**EL PASO COUNTY PLANNING AND
 COMMUNITY DEVELOPMENT
 DEPARTMENT**

GRADING AND EROSION CONTROL PLAN CHECKLIST

GRADING & EROSION CONTROL PLAN
CLAREMONT BUSINESS PARK 2 FIL. NO. 1 - LOT 2
JOB NO. 44-037
DATE PREPARED: OCTOBER 09, 2020
DATE REVISED:

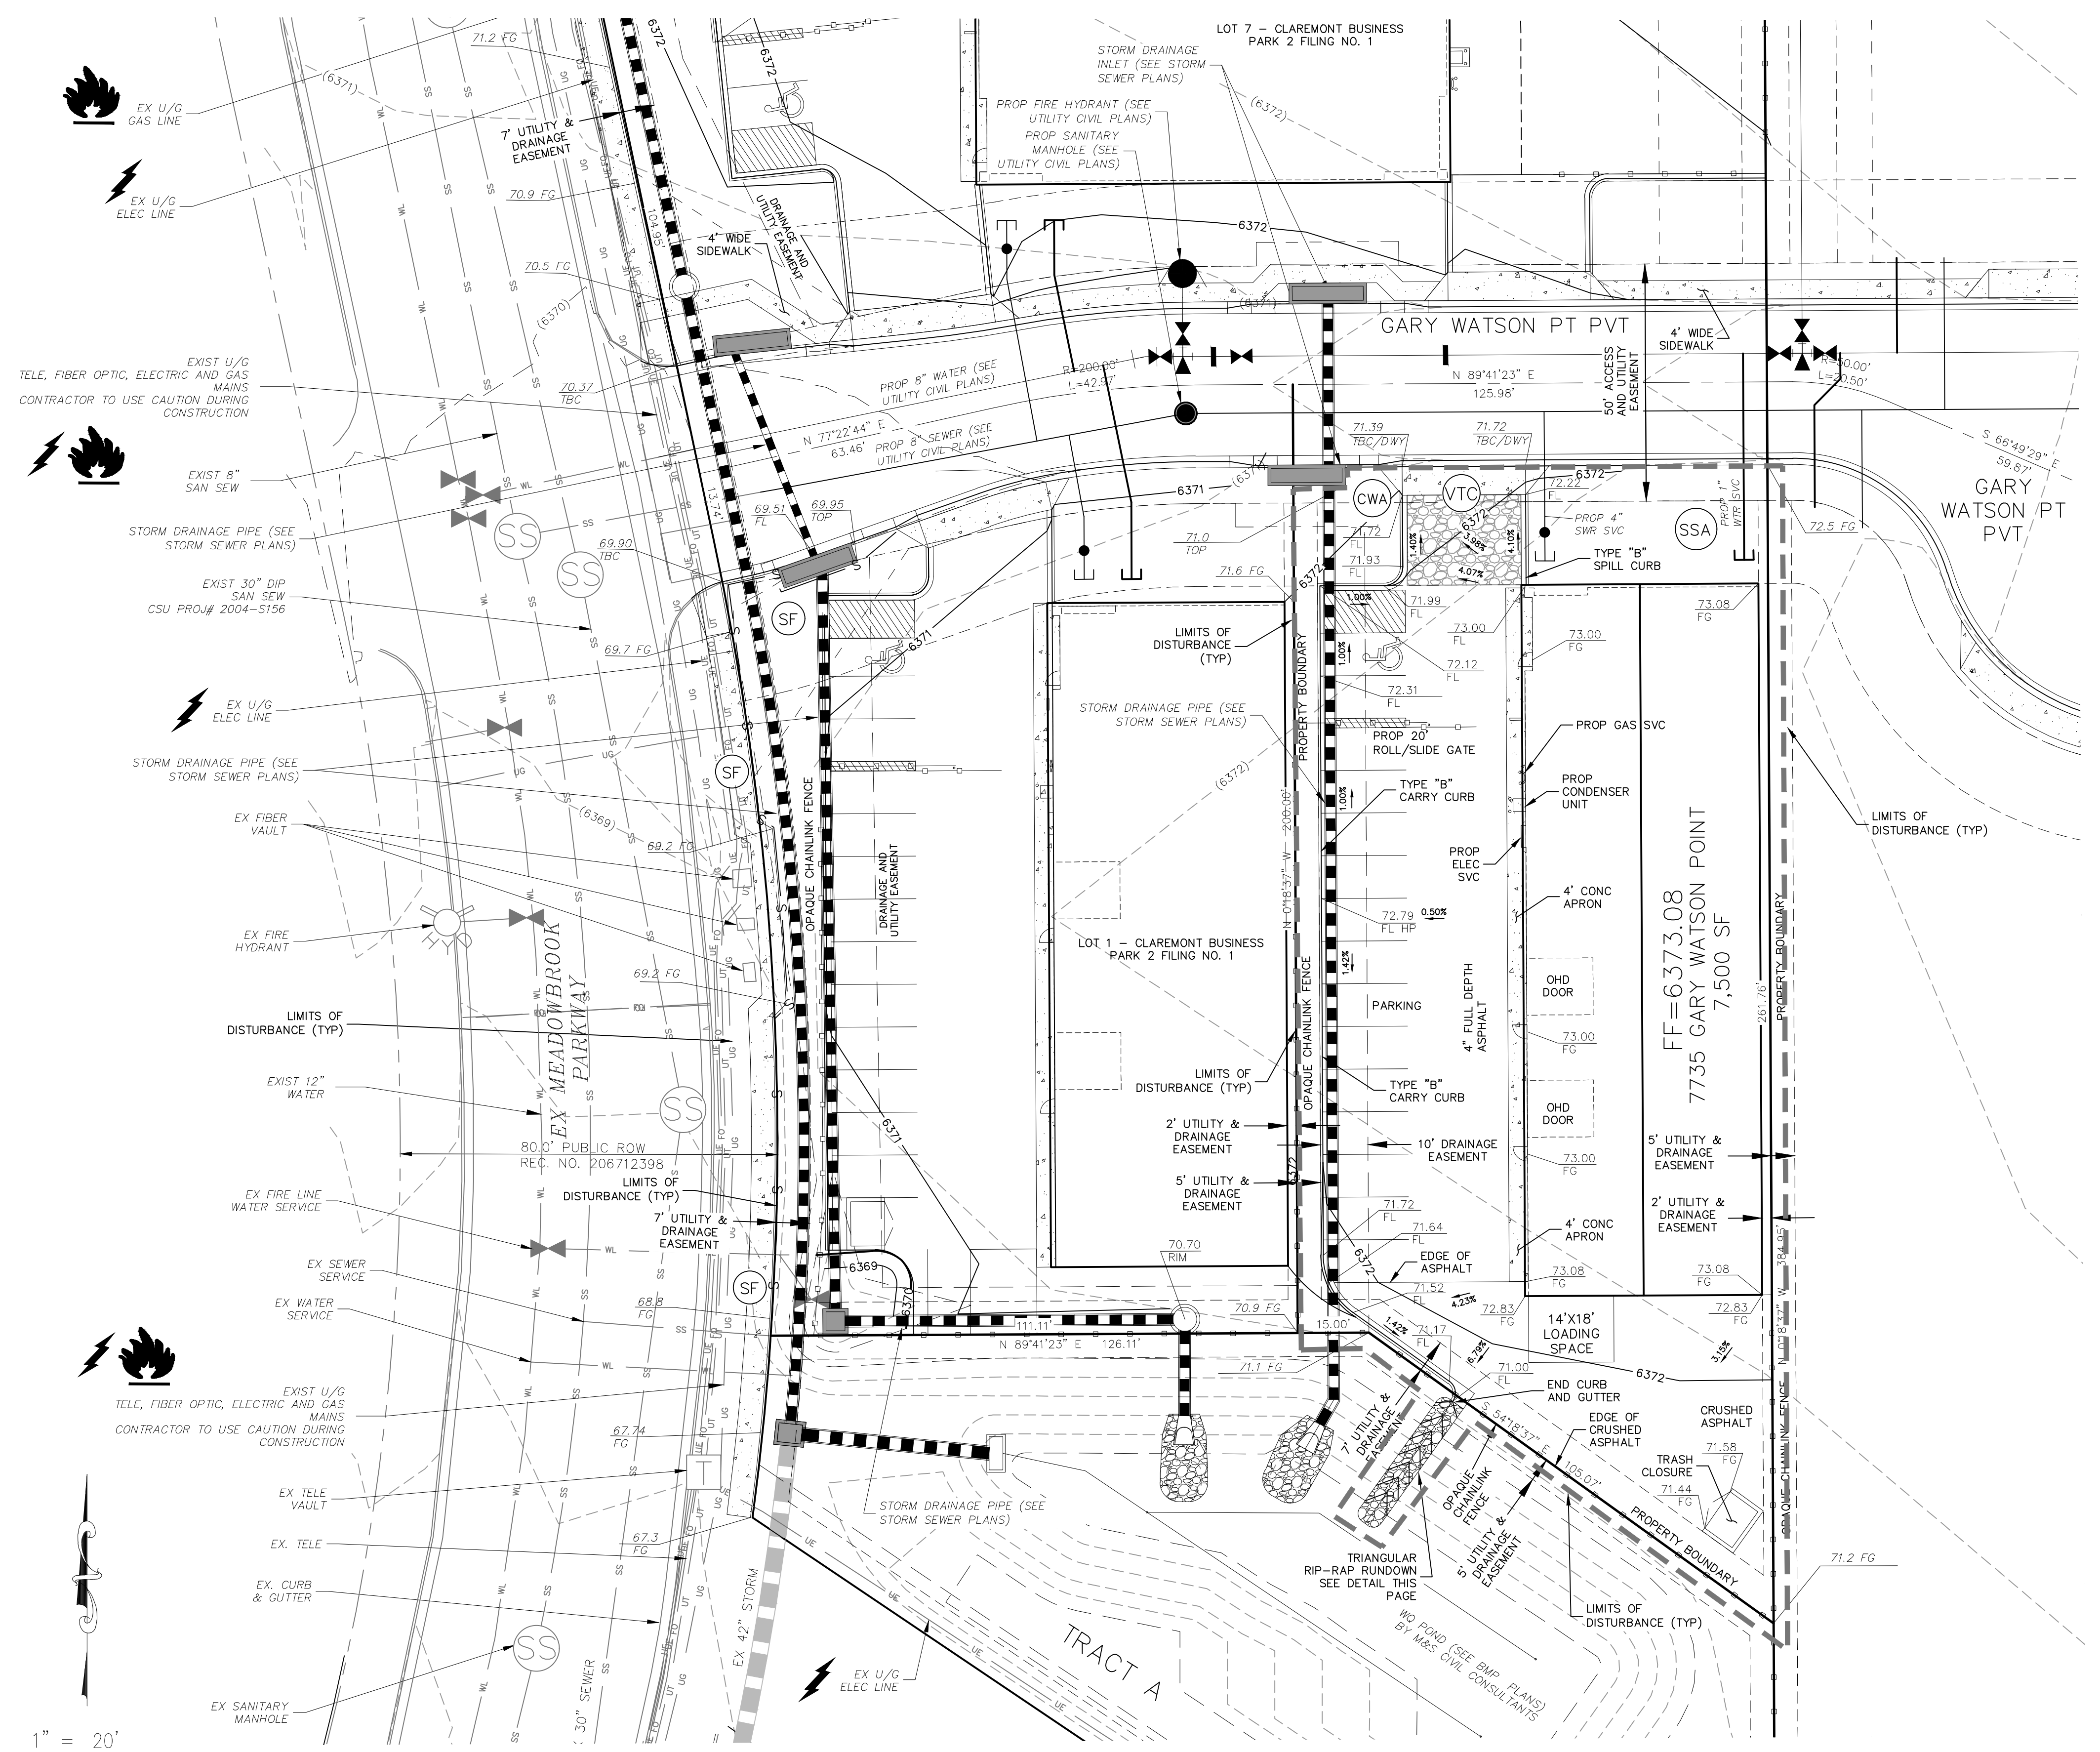
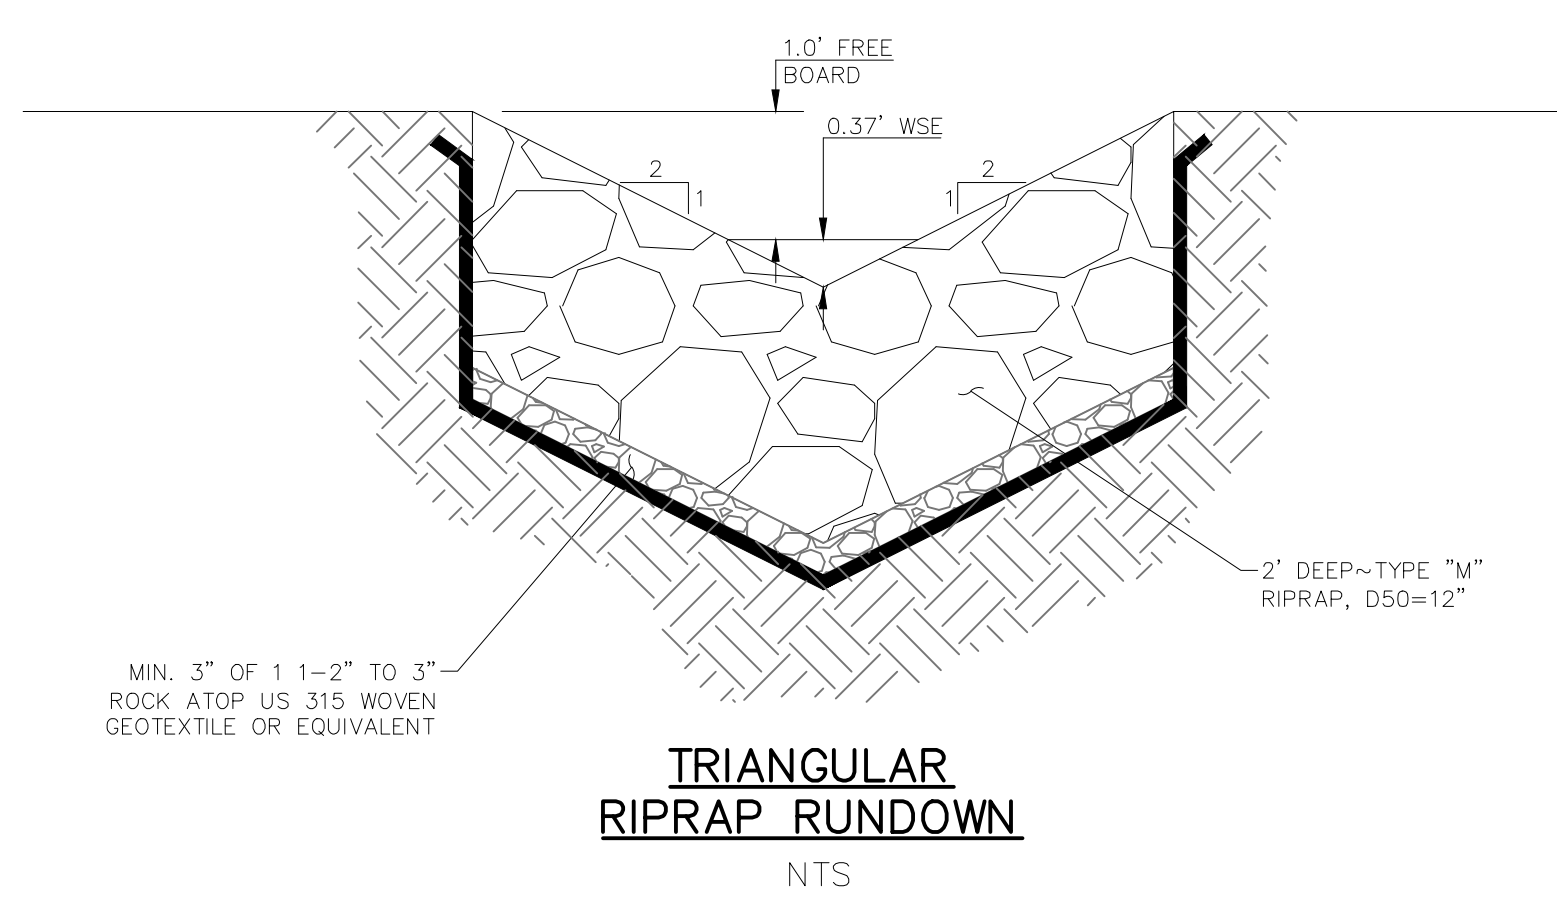
v	All proposed temporary construction control measures, structural and non-structural. Temporary construction control measures shall be identified by phase of implementation to include "initial," "interim," and "final" or shown on separate phased maps identifying each phase.	X	✗
w	Vehicle tracking provided at all construction entrances/exits. Construction fencing, barricades, and/or signage provided at access points not to be used for construction.	X	✓
x	Temporary sediment ponds provided for disturbed drainage areas greater than 1 acre.	N/A	N/A
y	Dewatering operations to include locations of diversion, pump and discharge(s) as anticipated at time of design.	N/A	N/A
z	All proposed temporary construction control measure details. Custom or other jurisdiction's details used must meet or exceed EPC standards.	X	✗
